26 June 2019

Your Ref: SSD 9772

Comments for Santa Sophia Catholic College (SSD 9772)

Figure 2 – Height Plane –Surrounding Development Context

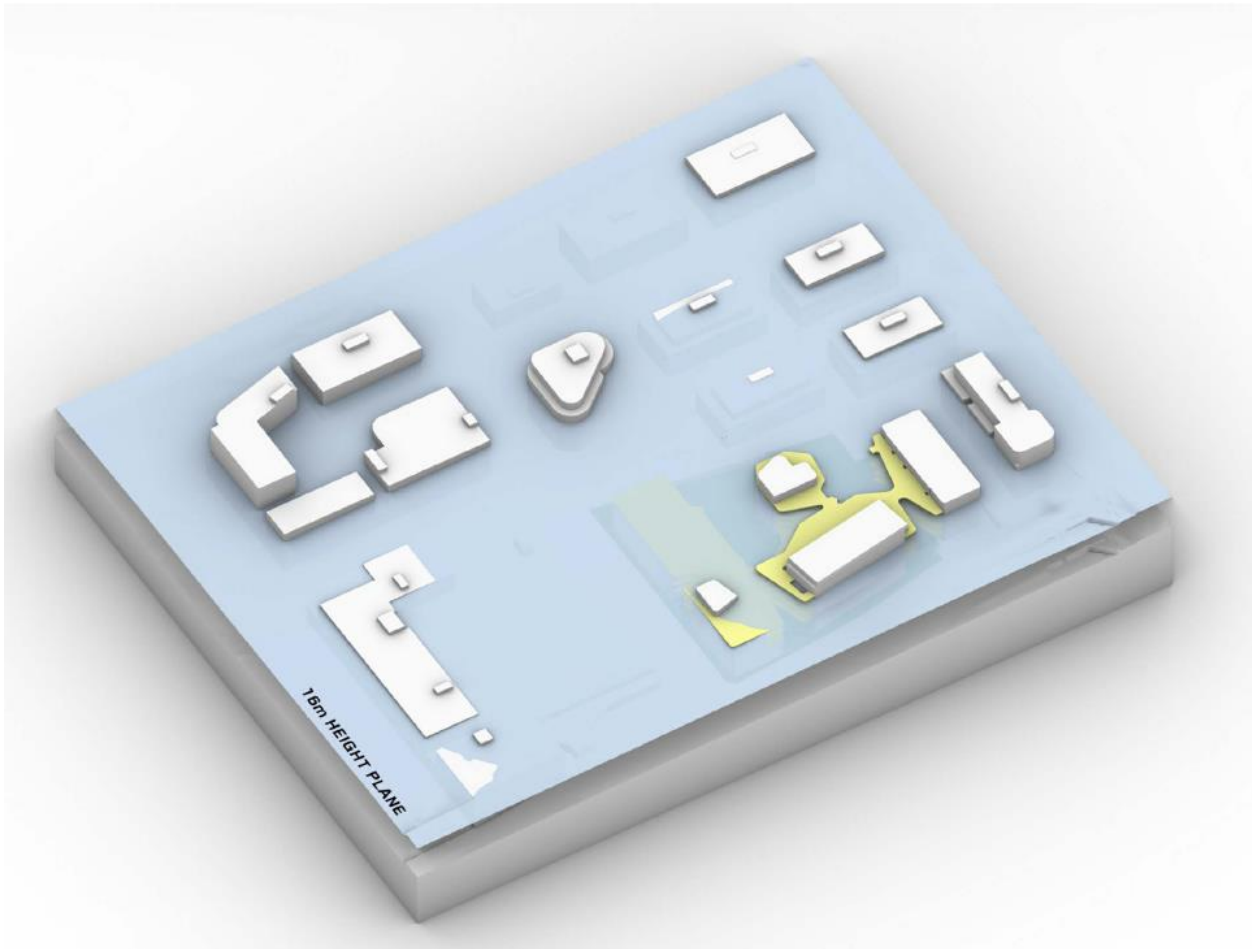
As identified above, the school site is subject to a 16 metre height limit. The proposal appears to rely on the proposed heights of the surrounding development lots included in the planning proposal to justify the height notwithstanding the reasoning provided by to Council for the increase in height in the planning proposal was to offset the loss of area occupied by the school. It is considered that the planning proposal is not considered imminent or certain and therefore should not be relied upon in justifying the height contravention.

Further to this, the subdivision works plan for the town centre roads (Development Application 1542/2019/ZB) propose to cut the roads that frame the school site by some 2m

to 3m. This results in the actual building height being approximately 29.5m above future finished ground levels.

Although this is a matter for the Department, the justification of the height contravention appears deficient.

Figure 4 – Secondary Pickup Dropoff

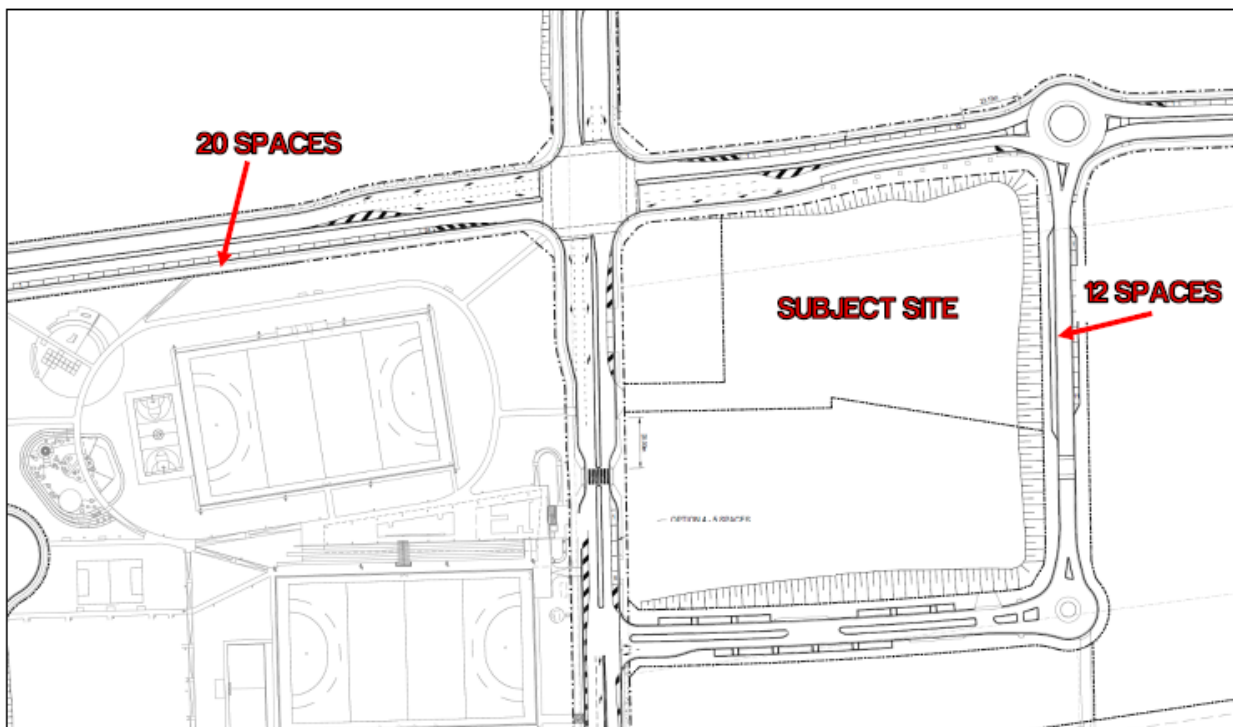
It is also noted that the pick-up drop-off area will not be sufficient once the school has reached full capacity. Given the location within the town centre, it is recommended that further measures be put in place to support student pick up and drop off.
